8 September 2017

SSD 6611 MOD1 – COCKLE BAY MARINE STRUCTURE RENEWAL

Cockle Bay Marine Structures
Developed Design
General Arrangement Plan

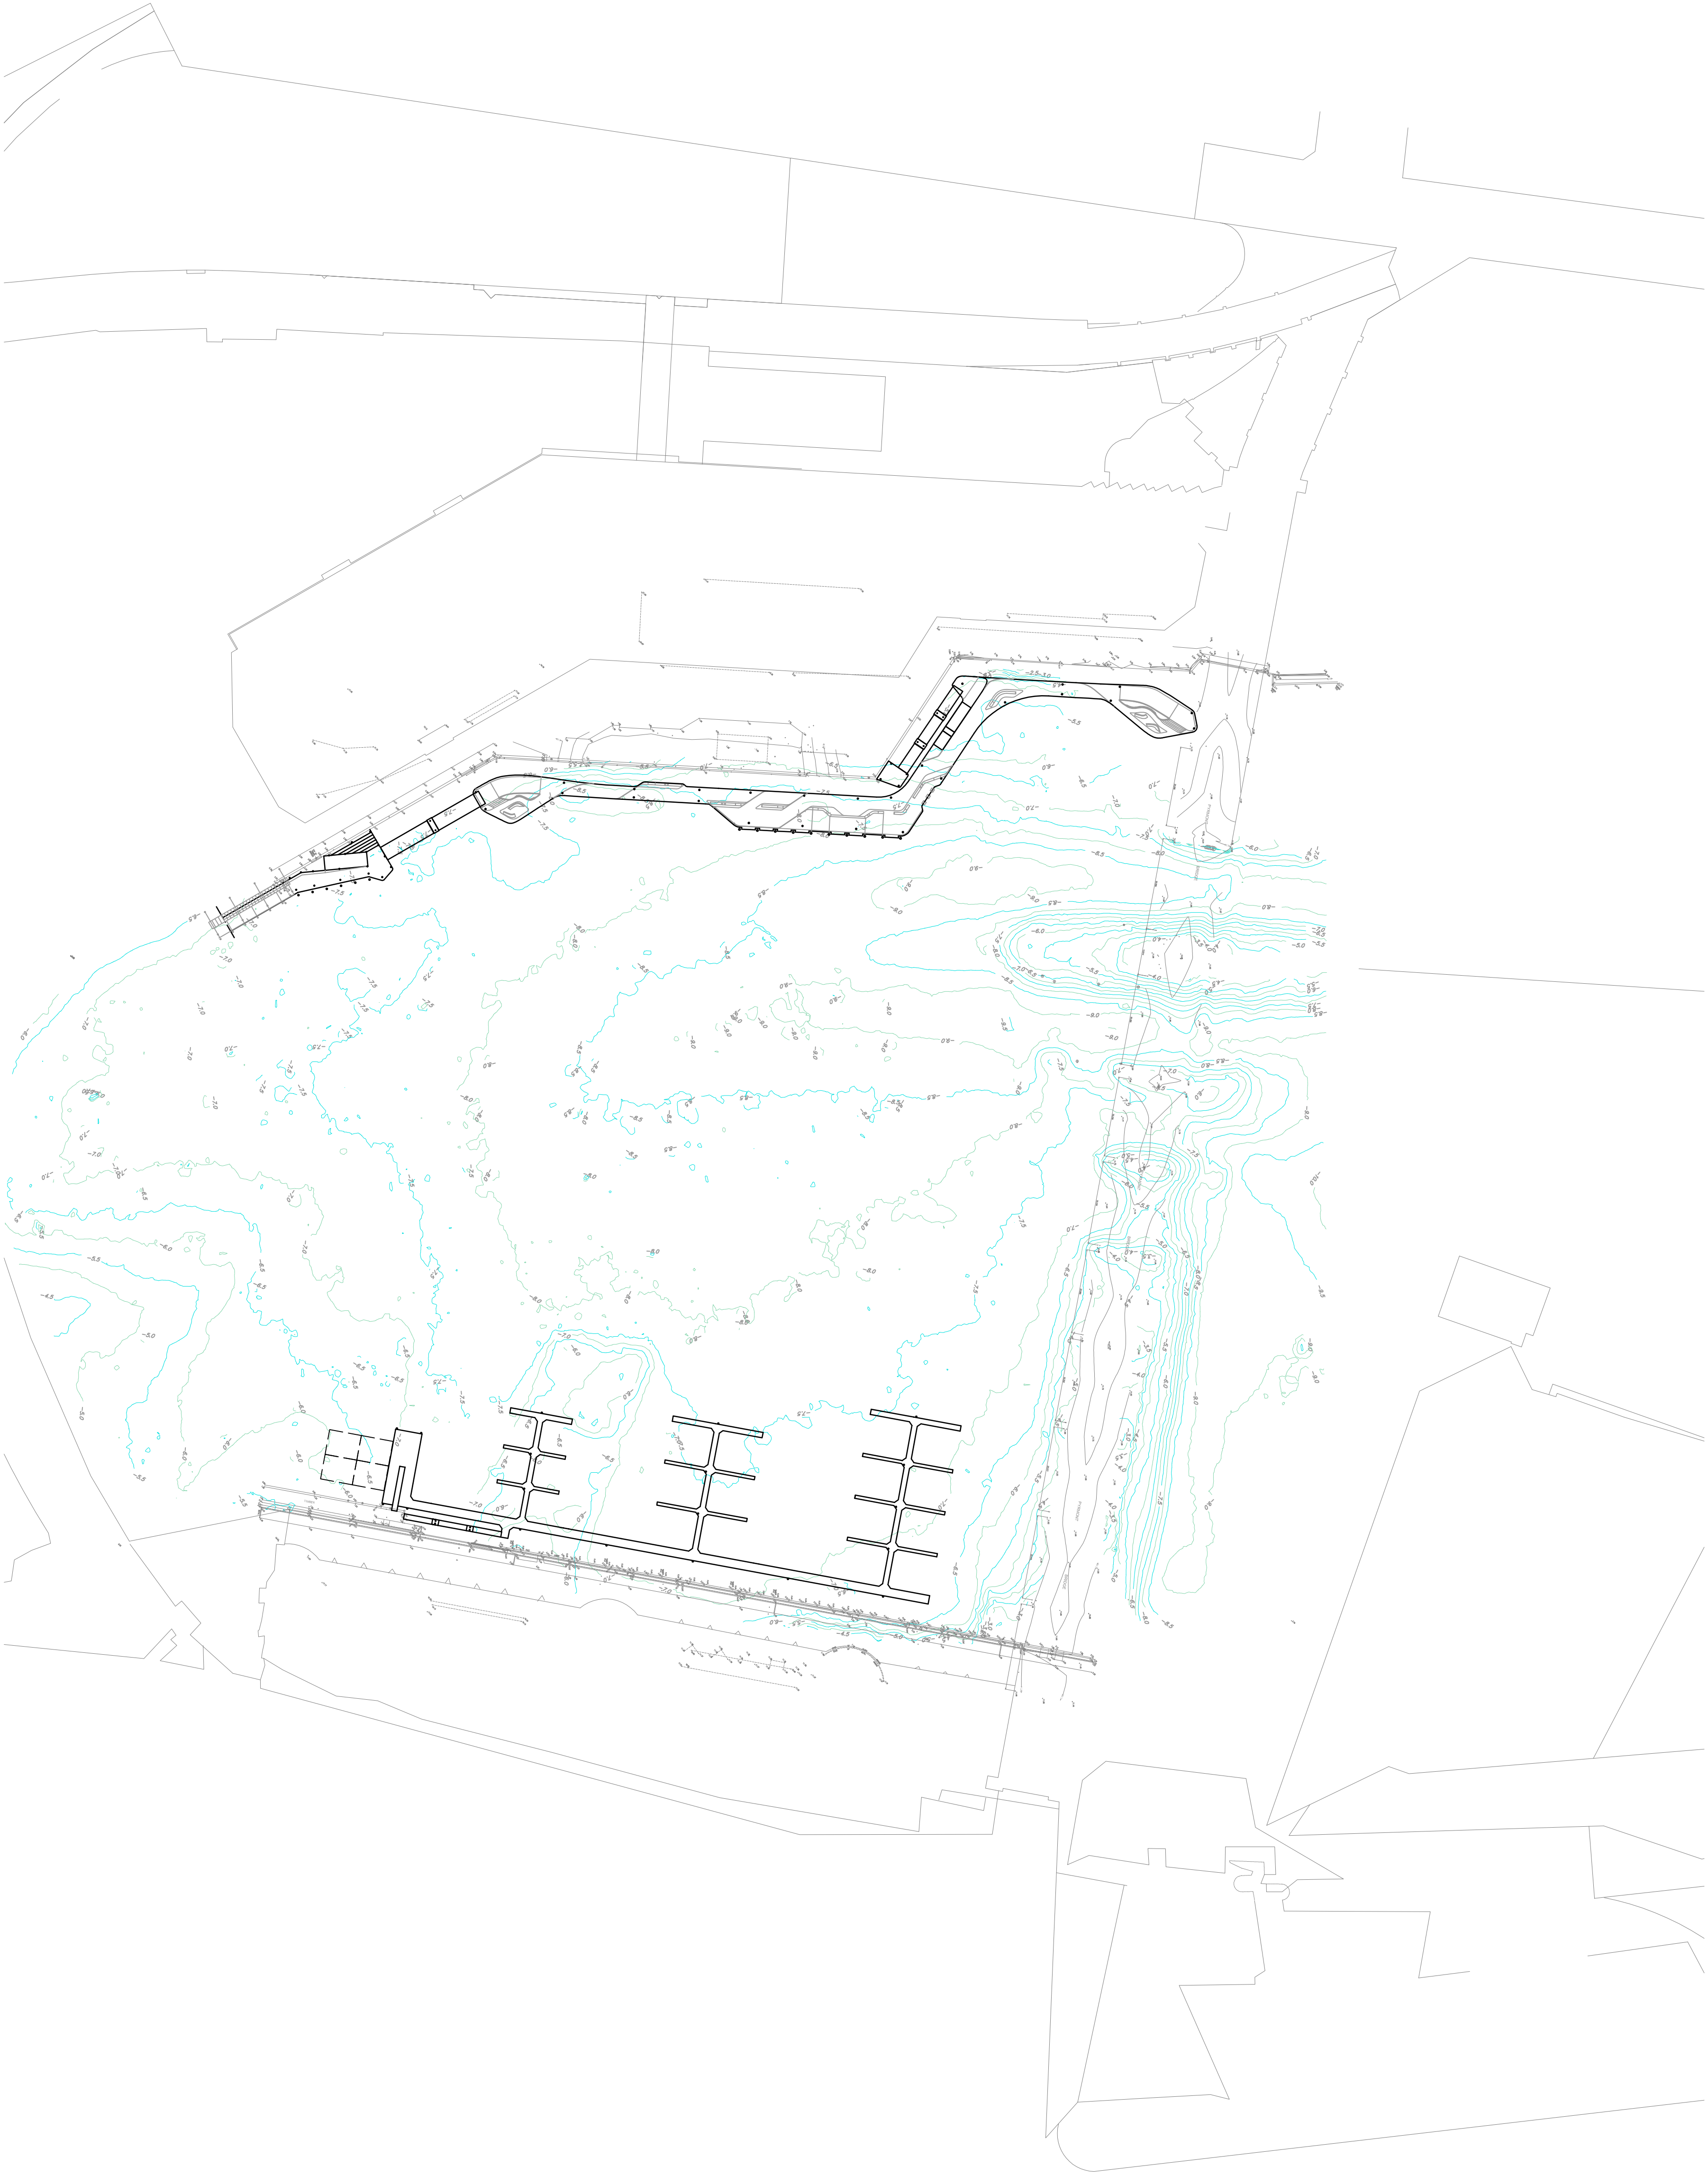
The EPA understands that the modification application is intended to enable construction of a floating walkway secured by piles fixed into the harbour floor.

The EPA is concerned that the piling installation work is likely to generate significant noise impacts. And, understands that unless a jack-up barge is used to provide a stable work platform, work would be required to be undertaken during calm conditions which typically occur during the night.

- (a) despite numerous residences (example: Barangaroo) as well as other noise sensitive land uses having been completed nearby since the original consent was issued, the applicant seeks to rely on the original noise impact assessment;
- (b) current consent condition C1(b) is inconsistent with the recommended standard construction hours for Saturdays; and
- (c) current consent condition E8 incorrectly refers to the pump out of 'sewerage' instead of 'sewage' (i.e. sewerage means a system of sewers in which sewage is conveyed)

- (a) consent condition C1 (b) be modified to adopt the recommended standard construction hours for Saturdays of 8.00 am to 1.00 pm, particularly in respect of piling work (removal and installation),
- (b) the proponent be required to adopt all feasible and reasonable construction methods to avoid the installation of piles outside the recommended standard construction hours;
- (c) the proponent be required to install piles using the least noisy construction method; and
- (d) consent condition E8 be emended to delete the word 'sewerage' and insert instead the word 'sewage'.
